**Hartcliff Road, Penistone
Proposed Residential Development
Designers Response to Stage 1 Road Safety
Audit for the Proposed Highway Works
At Hartcliff Road/Chapel Lane**

August 2014 (Initial Issue)

STATUS	PRELIMINARY
PROJECT	HARTCLIFF ROAD, PENISTONE
DRAWING TITLE	POTENTIAL HARTCLIFF ROAD/CHAPEL LANE SIGNALISED HIGHWAY IMPROVEMENTS

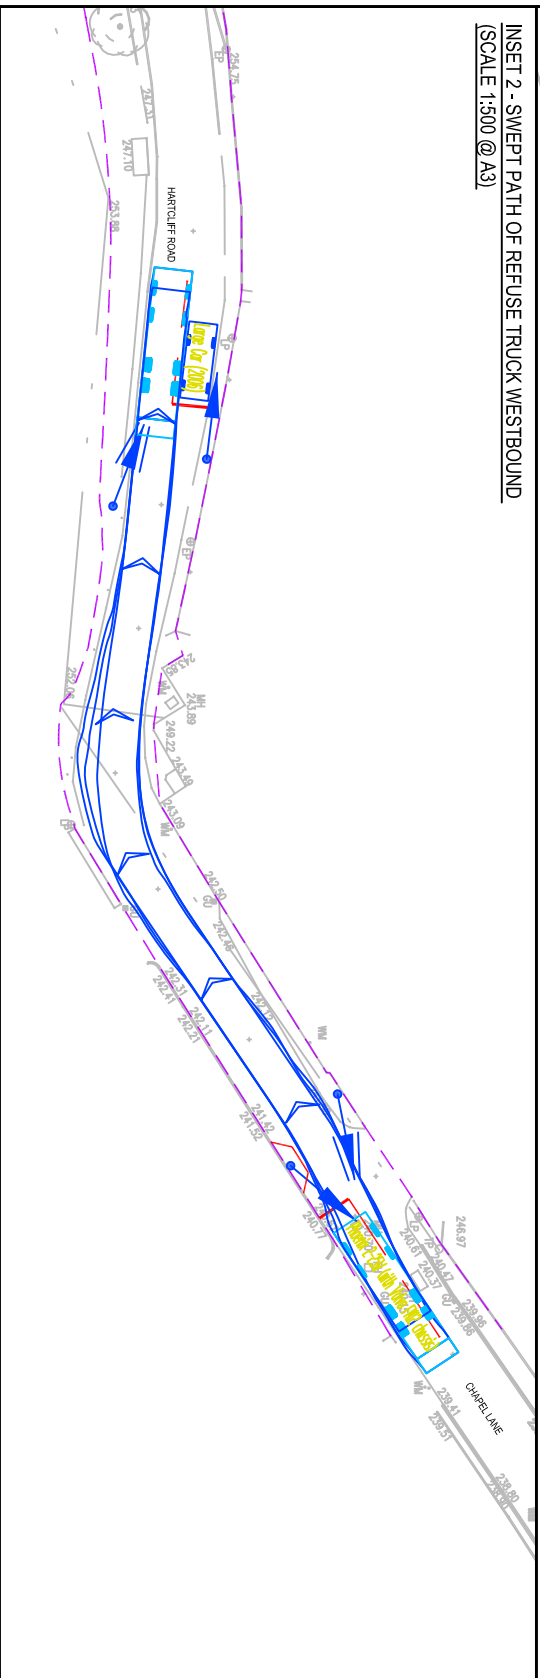
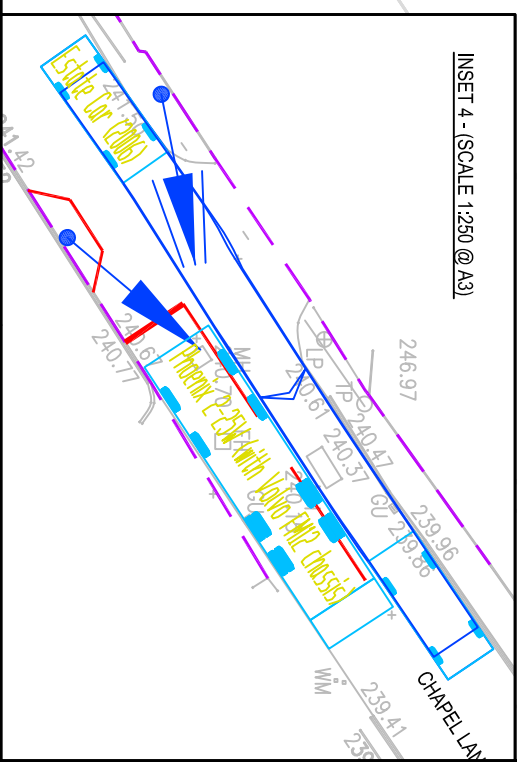
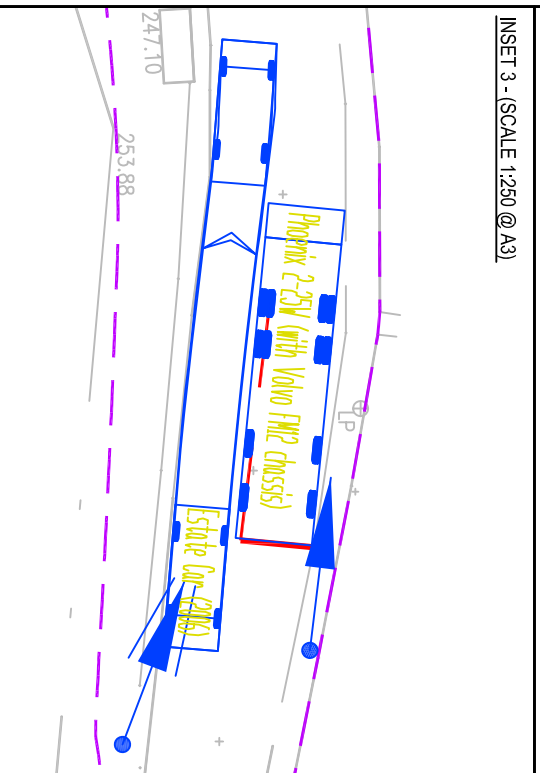
Summary: *The proposed build out is close to a private drive serving several properties. Vehicles using this drive may be obstructed by the new feature and mount the footway placing pedestrians at risk.*

The proposed build out on the Chapel Lane approach to the signals is located almost opposite a private drive serving several residential properties. Whilst some vehicle

swept path information was provided to the Audit Team for a vehicle turning left in to the drive this appears to be very tight with no margin for driver error and there was no swept path shown for a vehicle turning right out of the drive. It is therefore unclear whether a vehicle will be able to turn left in to or right out of the drive without either over running the northern footway or mounting the build out and be in conflict with pedestrians and the new signal equipment placed in these areas.

The Design Team shall carry out swept path analyses to demonstrate how the vehicles anticipated to use the private drive will be able to do so without over running existing or proposed footway / build out areas or colliding with signal equipment.

Drawing 12006-ATR-05 Rev B attached in Appendix B illustrates a swept path analysis including all manoeuvres. The swept path analysis confirms that the largest expected vehicle (car and caravan) can be accommodated accessing and egressing the private residential dwellings. Notwithstanding this it should be noted that the vast majority

of traffic utilising these access points will be a private cars routing via Mortimer Road which can comfortably be accommodated.
